**Lang Walker AO Medical Research Building - Macarthur (SSD-17491477)  
Response to Submissions**

## **Attachment 1**

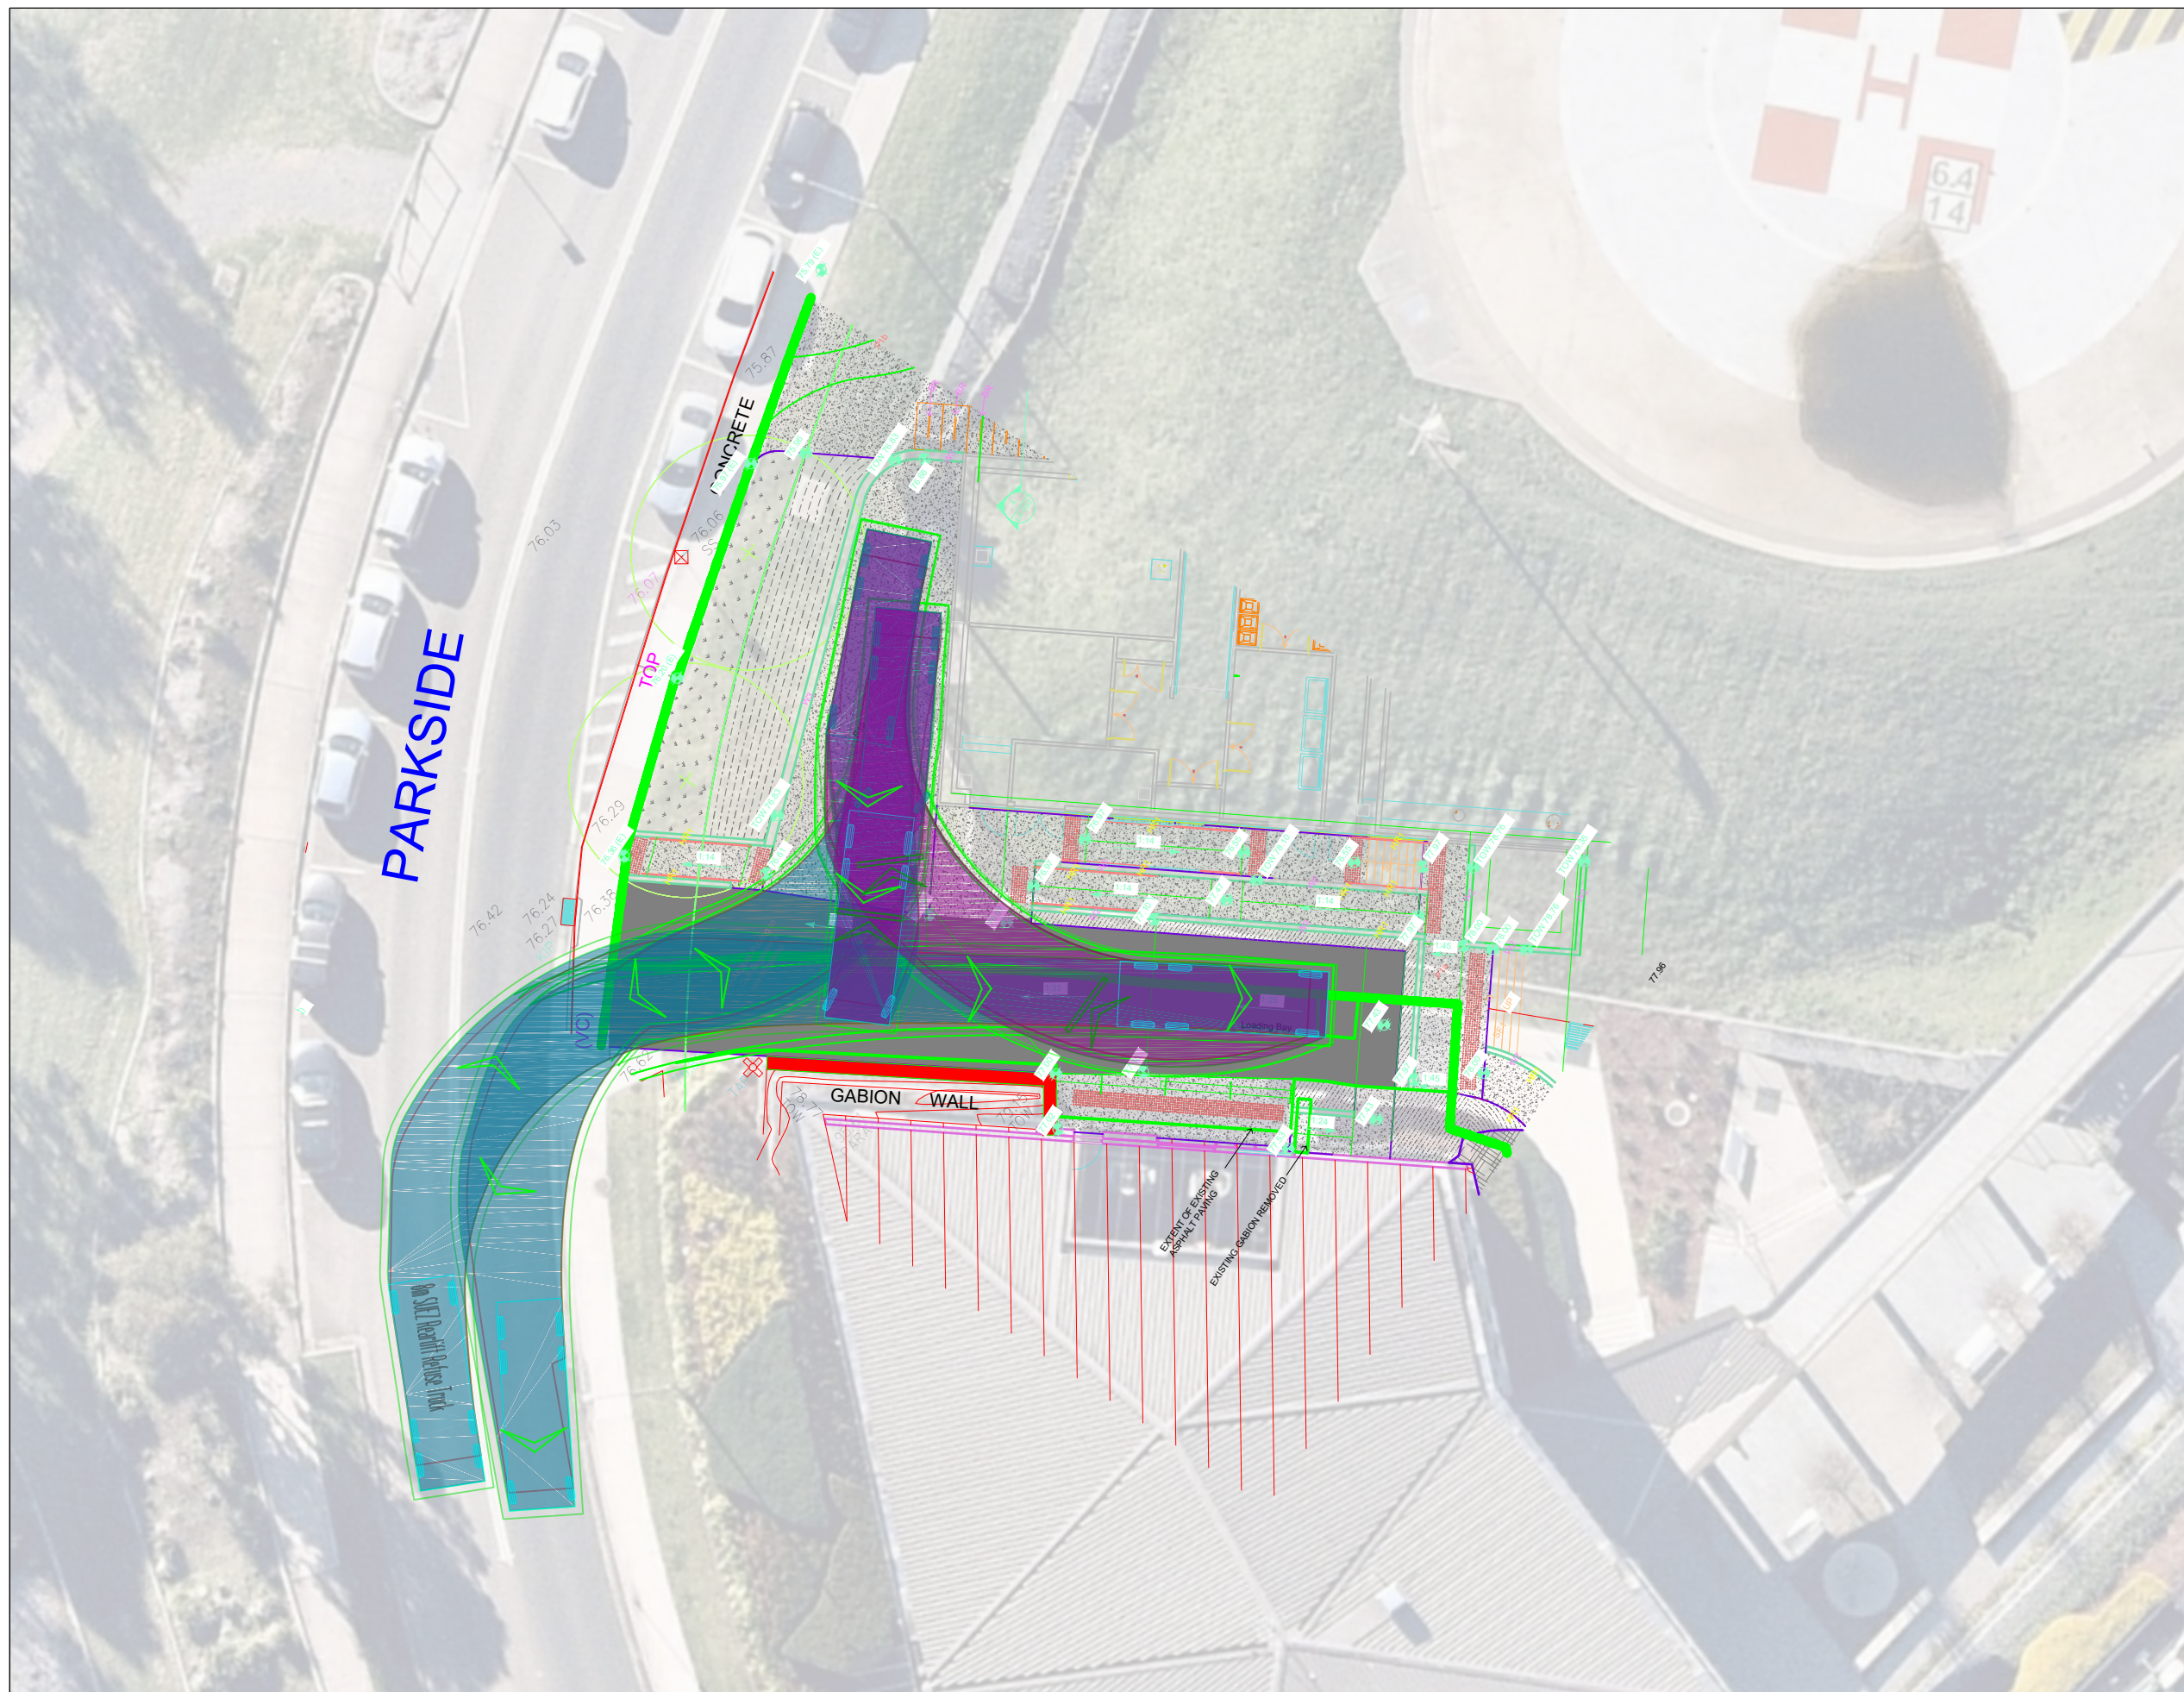
2. Amended plans are to be submitted displaying the location of visitor bicycle storage racks in vicinity of both the Parkside Crescent entrance and village green entrance.
3. An indicative layout plan is to be submitted showing the location and walking distances to the research centre's assigned standard and mobility impaired parking spaces. In addition, access routes from mobility impaired car spaces must also confirm that direct travel paths and suitable gradients are provided to future staff and visitors.
4. Details are to be provided of the access arrangements, drop-off zone(s) and estimated frequency of university shuttle bus services.
